PLANNING CONSULTATION & SUBSTANTIVE RESPONSE

Application Number: 2025/0256
Site Address: 26 Laxton Road, Athersley North, Barnsley, S71 3DH

Erection of a single storey extension to existing building to extend the size of the gym facilities and amendments to car parking area

Proposed Eastern Rear Elevation
Scale 1:100

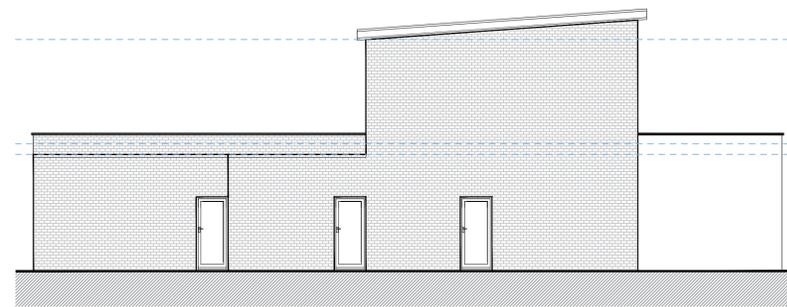
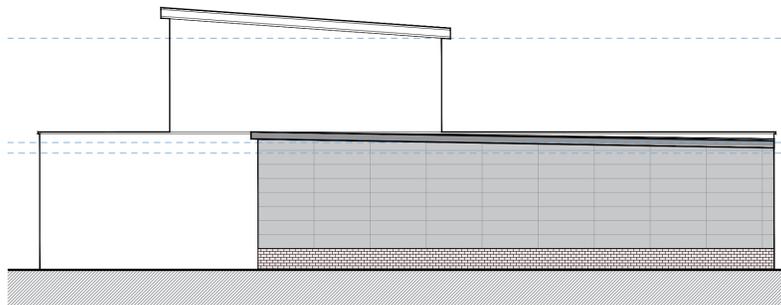
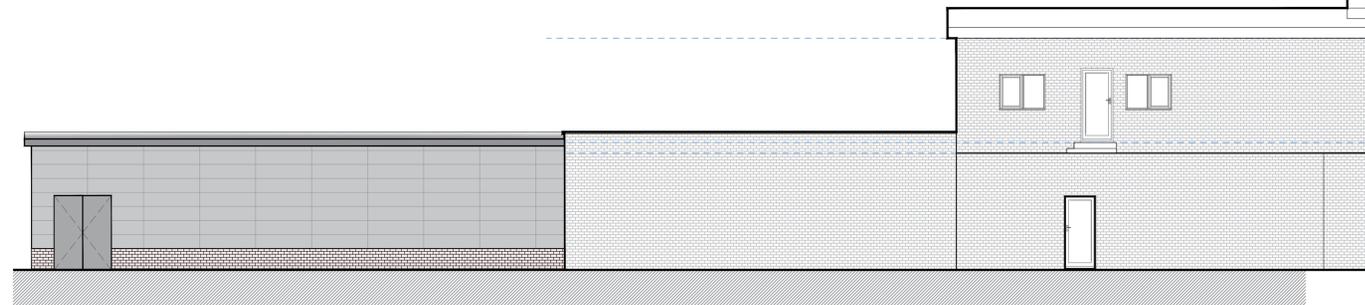
There is currently 22 meters from the rear of the proposed unit to the rear of an adjacent property. This does not align with Barnsley's SPD for Residential Amenity and the Siting of Buildings which asked for 25 meters.

Thank you for your recent comments regarding the proposed gym extension, specifically your note that the rear elevation of the new development would be located 22 metres from the rear elevation of the adjacent residential property to the west.

While we acknowledge that the SPD "Residential Amenity and the Siting of Buildings" provides a guideline of 25m for the separation between non-residential development and residential windows to habitable rooms, we would respectfully submit that a reduced distance of 22m is justified and acceptable in this case, due to several key mitigating circumstances:

The 25-degree rule from the BRE's "Site Layout Planning for Daylight and Sunlight" guidance has been applied to the proposal. A line taken at 25 degrees from the centre point of the lowest habitable room window on the rear elevation of the affected property would not intersect with the proposed extension, confirming that the structure will not materially impact the daylight access or amenity of that dwelling. This is supported in paragraph 3.4 of the SPD, which acknowledges that compliance with the 25-degree rule demonstrates acceptable levels of daylighting to neighbouring properties.

The proposed extension is single-storey in nature and therefore inherently limited in height and mass. It presents no risk of overbearing or overshadowing impacts typically associated with taller structures. As per SPD para. 3.7(1), while 25m is noted as a general separation guideline, the document also allows for flexibility where design-led solutions mitigate potential impacts.

Proposed Ground Floor Plan
Scale 1:100

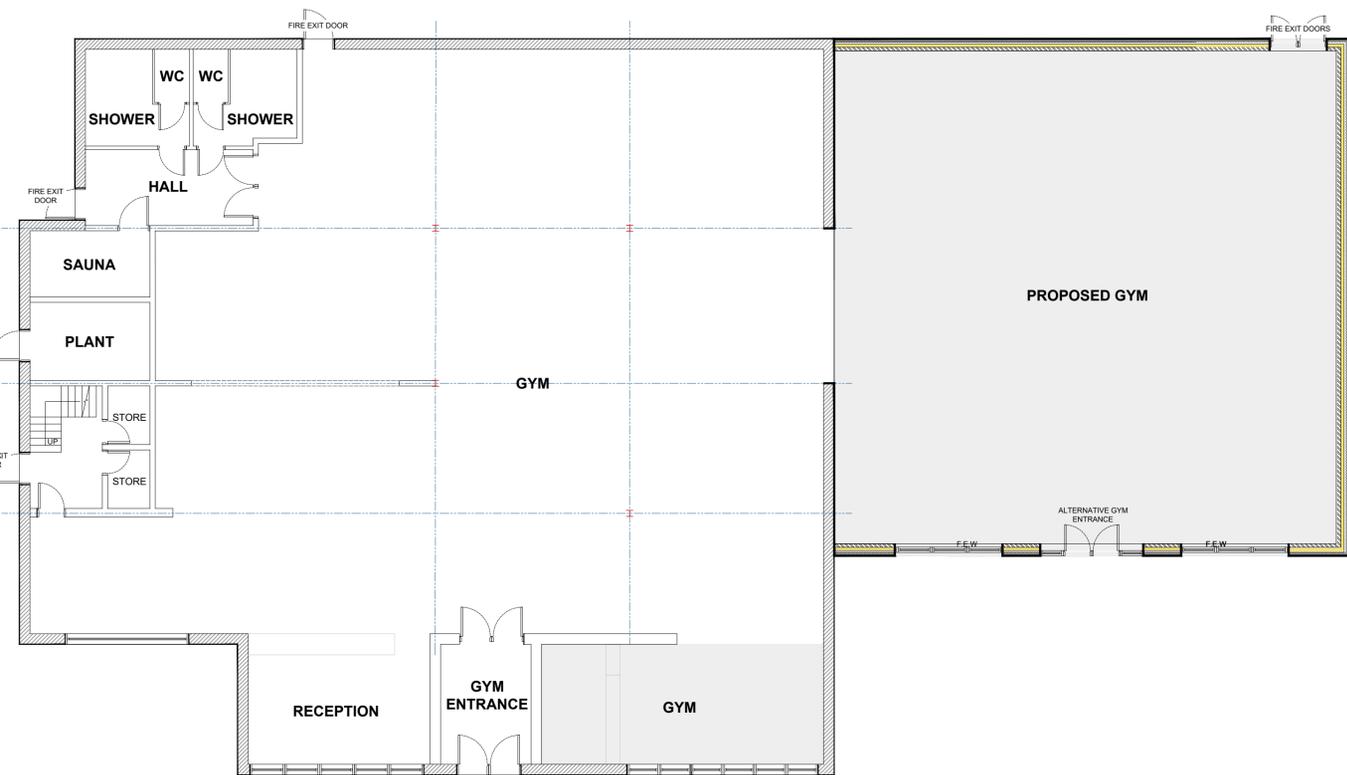
The Hot Food Takeaway on site

The existing building has a Hot Food Takeaway currently operating without any valid form of Planning Permission. A Hot Food Takeaway is not something that the LPA would usually support in this area and currently the Hot food Takeaway is at risk of action from Planning Enforcement. The Hot Food Takeaway does not have planning permission and has never has planning permission.

Whilst I can see that the applicant has rearranged the parking arrangements, I note that the staff parking spaces will result in blocking the previously arrived vehicle. Whilst this is not particularly a concern from a highways point of view, I would ask for clarification that staff members are not working shift patterns and there will no requirement for working staff members to have to rearrange vehicles to allow others to exit the car park.

The hot food takeaway has been removed from the proposals. The applicant acknowledges the councils and the agents' comments and intends to deal with this part of the building outside of this planning application.

Clarification: Staff work on an organised manner in regard to parking arrangements and the gym will incorporate a safe staff parking procedure that avoids any issues with this kind of parking and situations where people could be blocked in.
